Matter: M12 Motorway (SSI-9364)

Re: The University of Sydney's comment to the M12 Environmental Impact Statement (EIS)

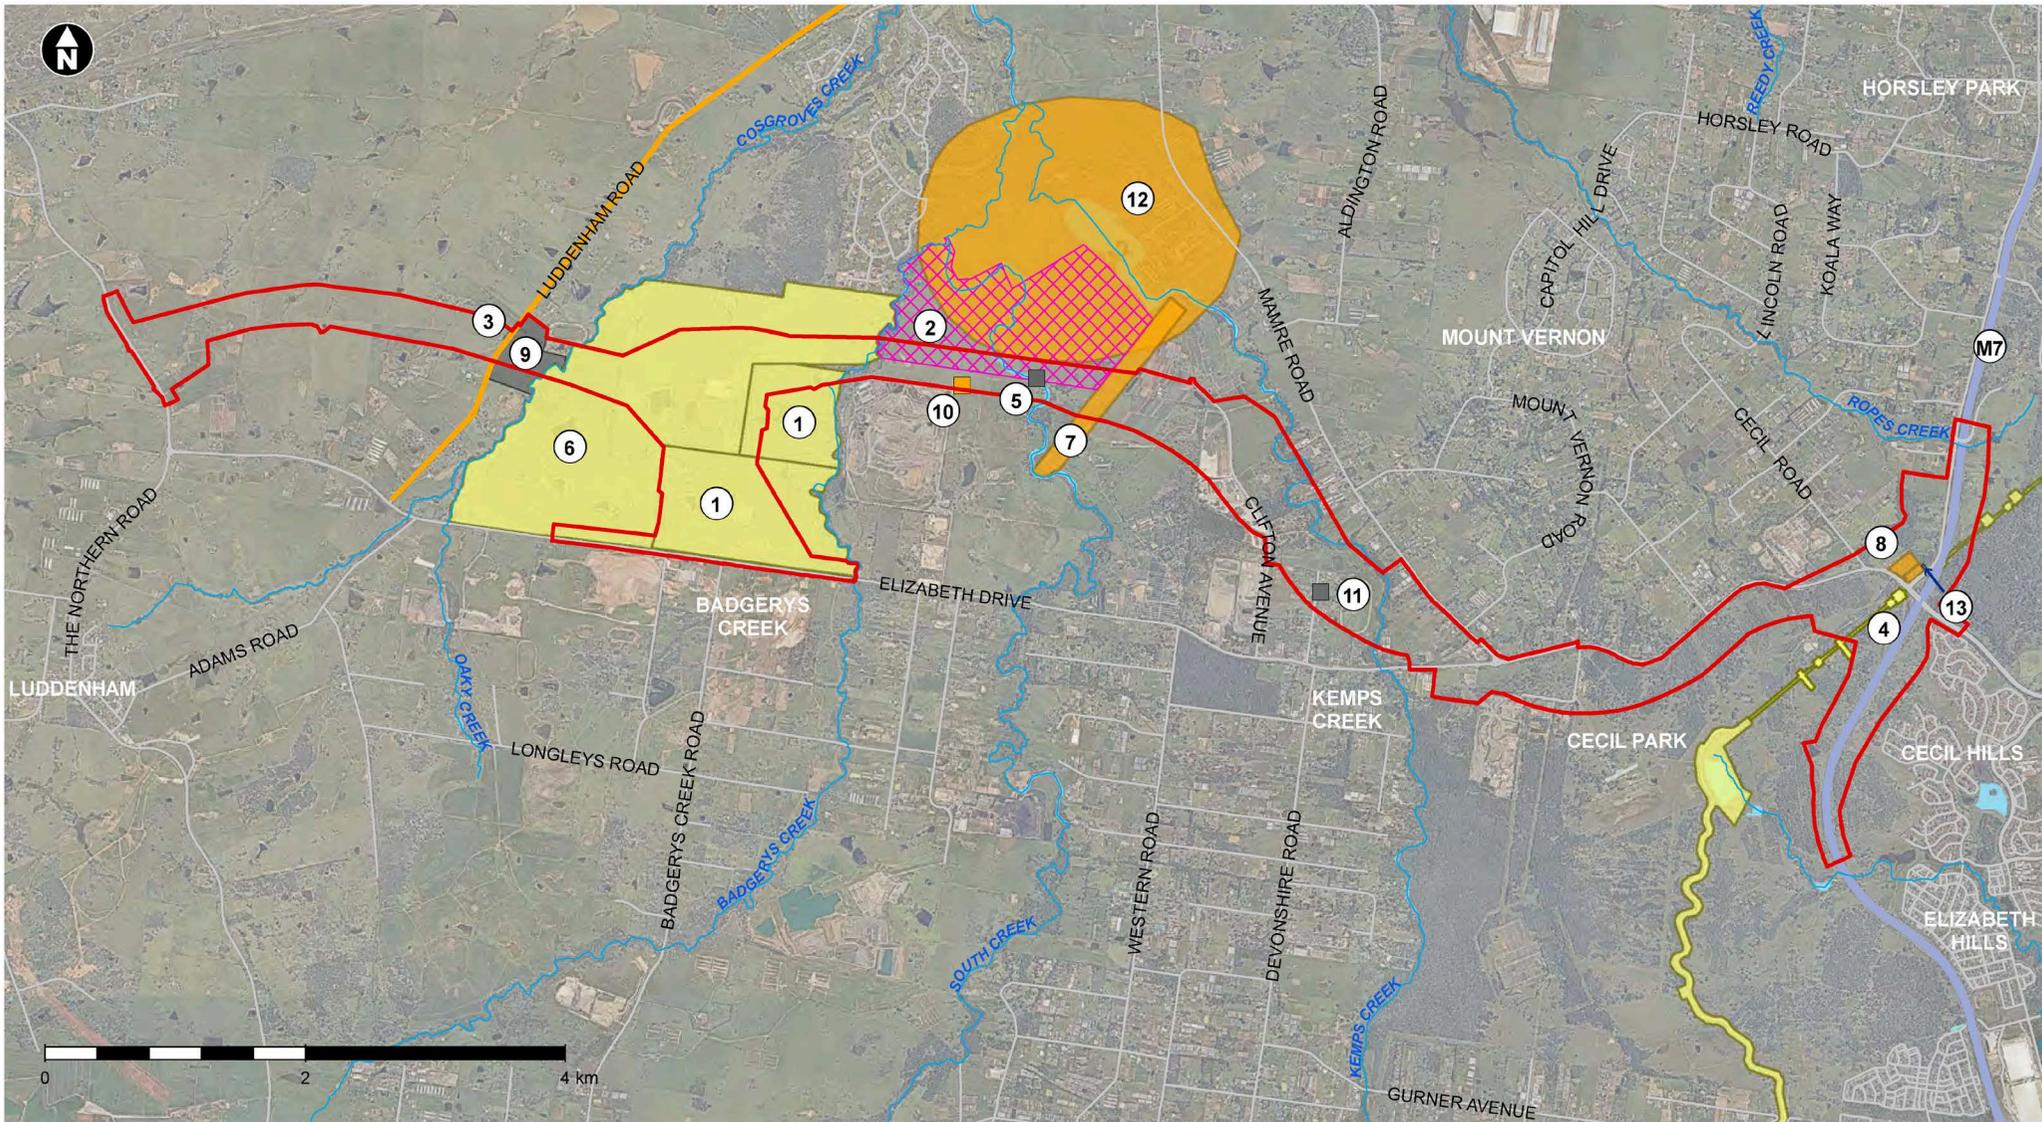
The EIS identifies the South, Kemps and Badgerys Creek Confluence Weirs Scenic Landscape as a heritage item based on rural landscape aesthetic. This landscape assessment has been derived from the 1990 Perumal Murphy Heritage Study for the Council (**Heritage Study**). The item was not listed as a heritage item in the Penrith Local Environmental Plan (2010).

The Heritage Study does not include the landscape as a cultural item for consideration in the listing and includes Perumal Murphy's statement (Davies 2007: vol.3:15:

*'This area with its remnant stands of paper bark and river she-oak along drainage lines and paddocks was listed as an area of high visual natural importance. However, it is not an item that belongs in a cultural heritage study and should not be listed in the revised LEP schedule.
The item is not recommended for listing on the LEP schedule.'*

On the above basis, we consider that the M12 Motorway non-Aboriginal Heritage report should be addressing the impact areas caused by the M12 Motorway project and not address areas not address areas outside the M12 Motorway.
